From: Debbie Farrell [REDACTED]
Sent: 29 July 2021 17:35
To: Andrew Wood <Andrew.Wood@arun.gov.uk>
Cc: Steven Shaw [REDACTED] Karl Roberts <Karl.Roberts@arun.gov.uk>
Subject: FW: LU/75/21

LU/331/17/PL

Erection of 4 employment units, flexible use classes B1c/B2/B8 with associated areas for car parking, service yard and landscaping

LU/75/21/DOC

Proposed Traffic Regulation Order Plan

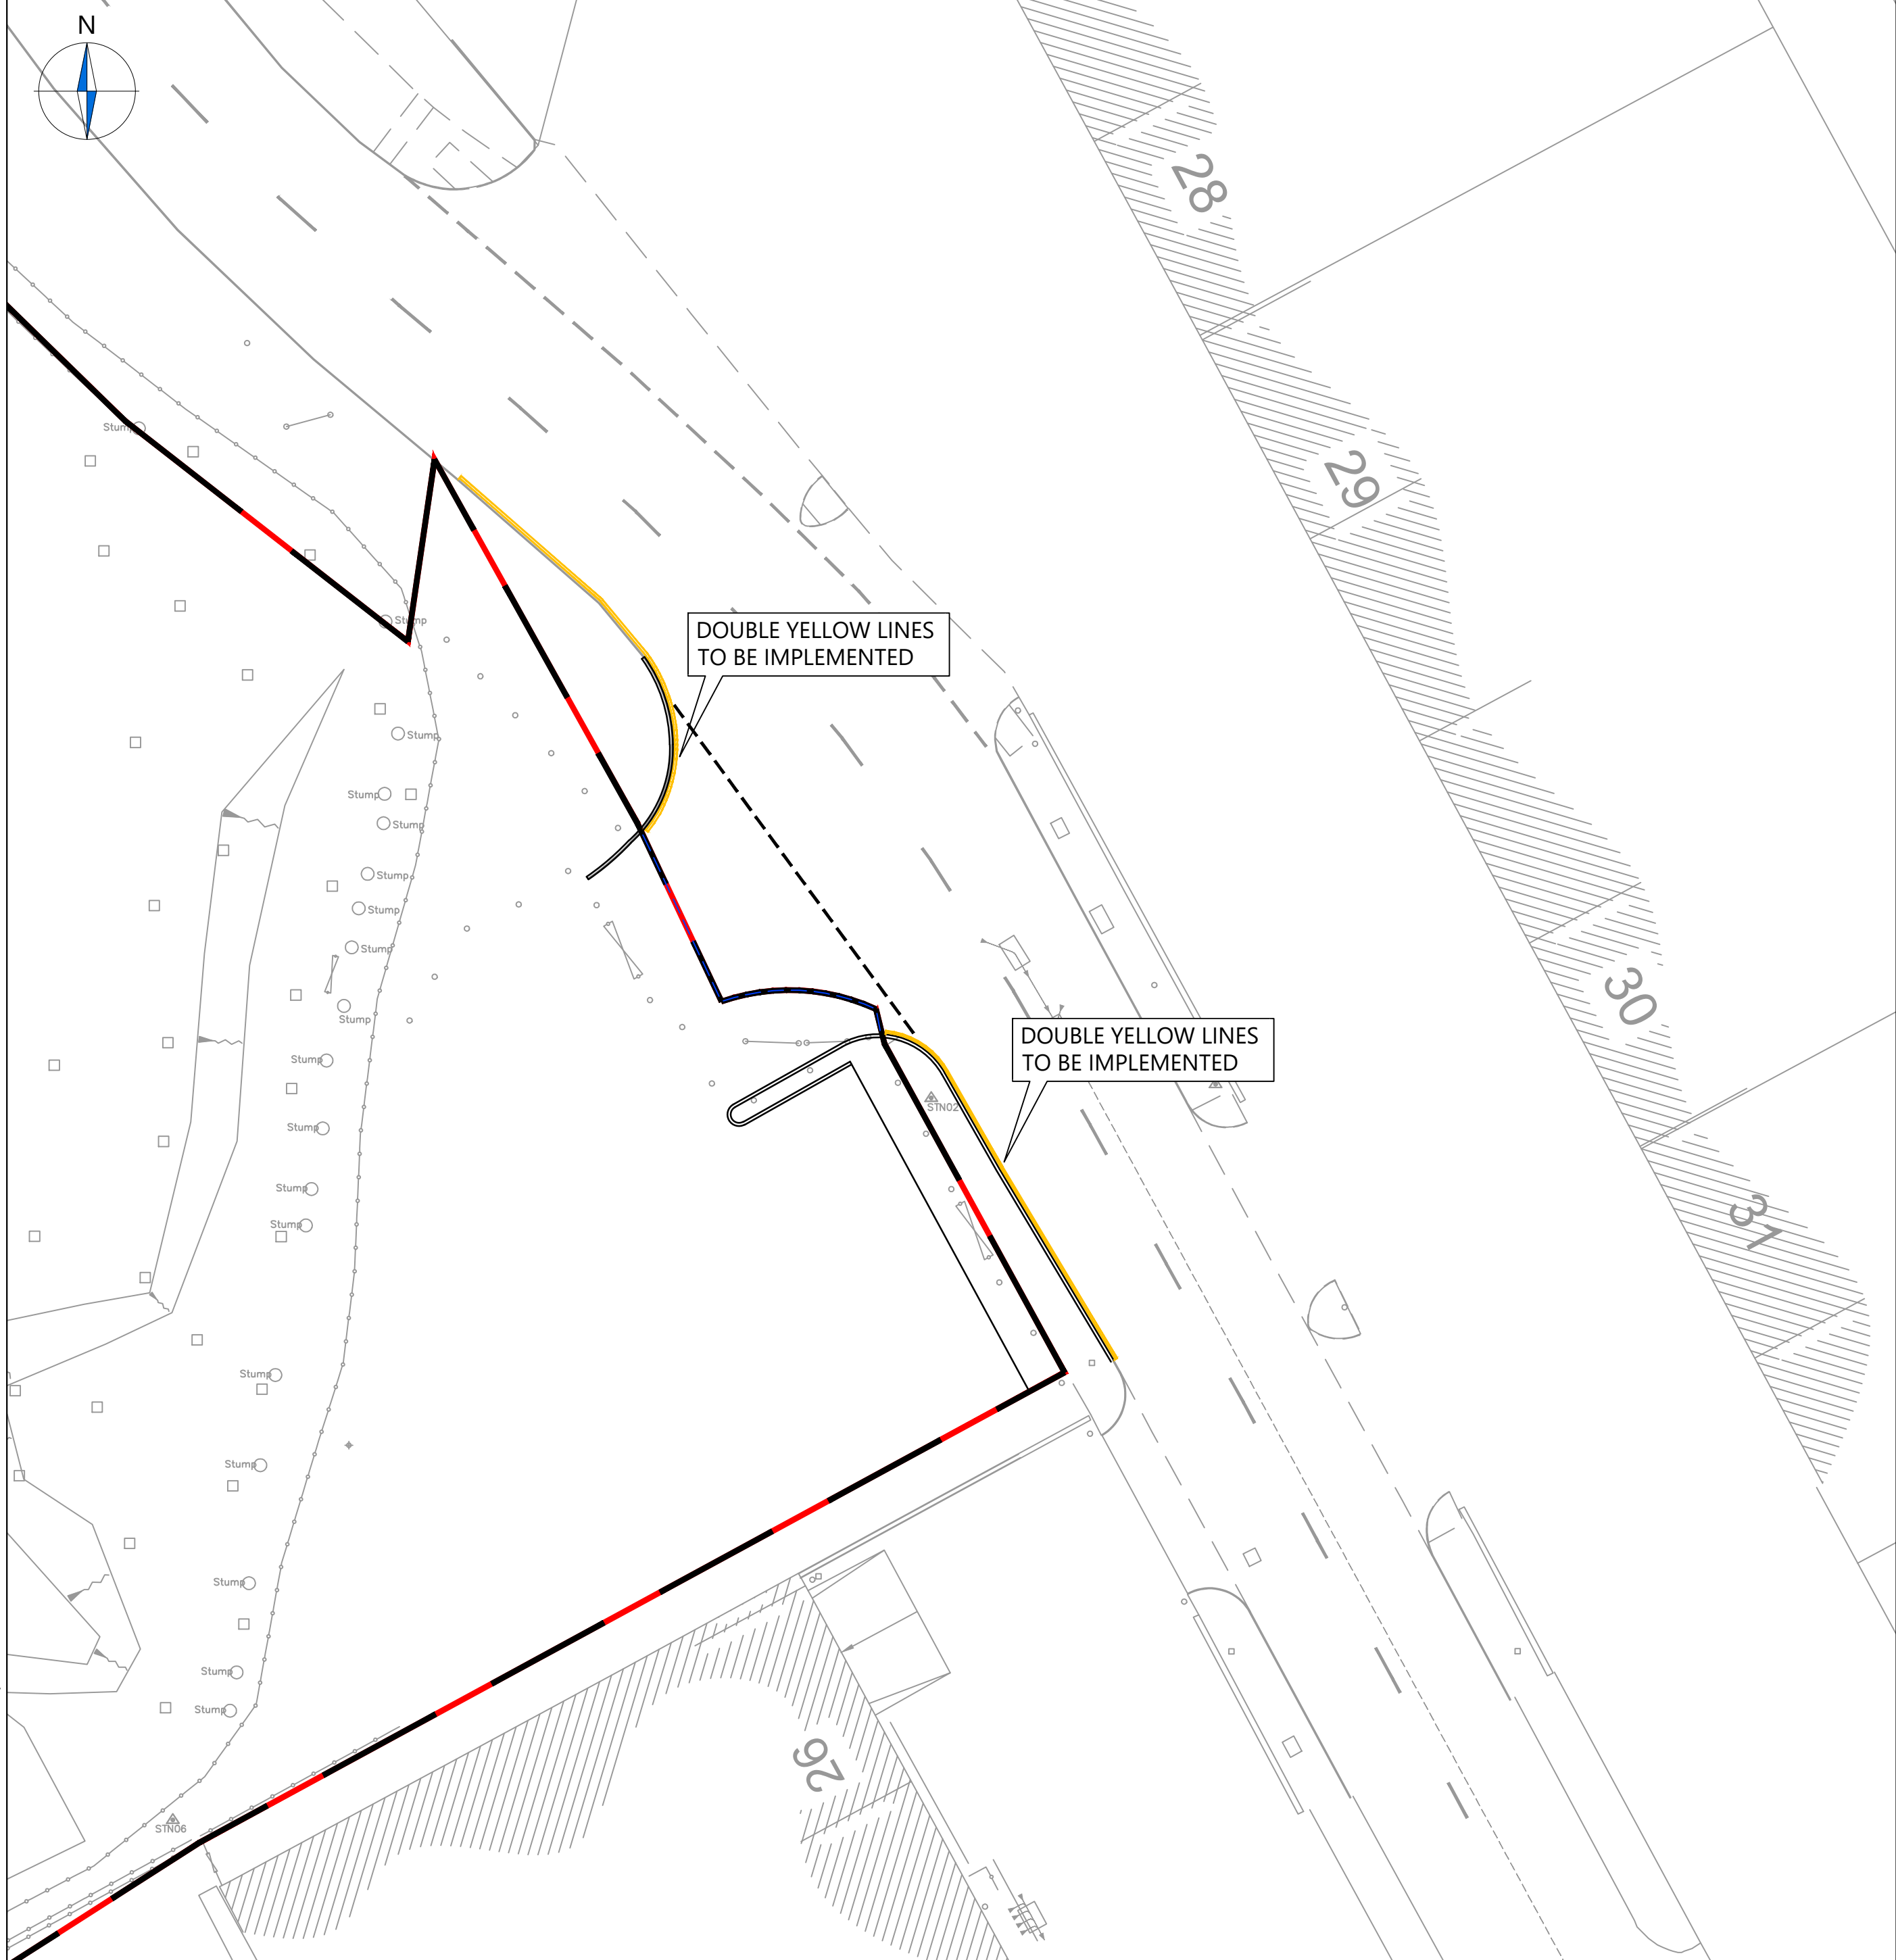
Problem 3.3.1 relates to concern over parking on the western side of the altered access and its impacts on larger vehicles entering the opposing carriageway when accessing/aggressing the junction. The Stage 1 RSA recommends that parking restrictions are proposed to the west of the altered access. Plan No: 3548.800.RevA Titled Proposed Traffic Regulation Order Plan has been submitted which shows the proposal for No Waiting restrictions.

The applicant has applied for the relevant Traffic Regulation Order and it is currently out for consultation until 12th August 2021. A decision shall be made following the consultation period and dependant on the nature and level of objections to the TRO. The no waiting at any time provision as proposed on Plan No: 3548.800.RevA is acceptable in principle to the Highway Authority in that they address the concerns raised in the Stage 1 RSA. From a planning perspective the TRO process is considered to be a separate post planning process and an applicant cannot be required to implement a TRO as it is subject to a separate statutory process and outside of their control. In light of this whilst the TRO has not currently been approved by the Highway Authority, as per the requirement of the condition, the Highway Authority would not wish to object to this condition on a planning basis.

The Highway Authority would not wish to raise an objection to the discharge of this condition.
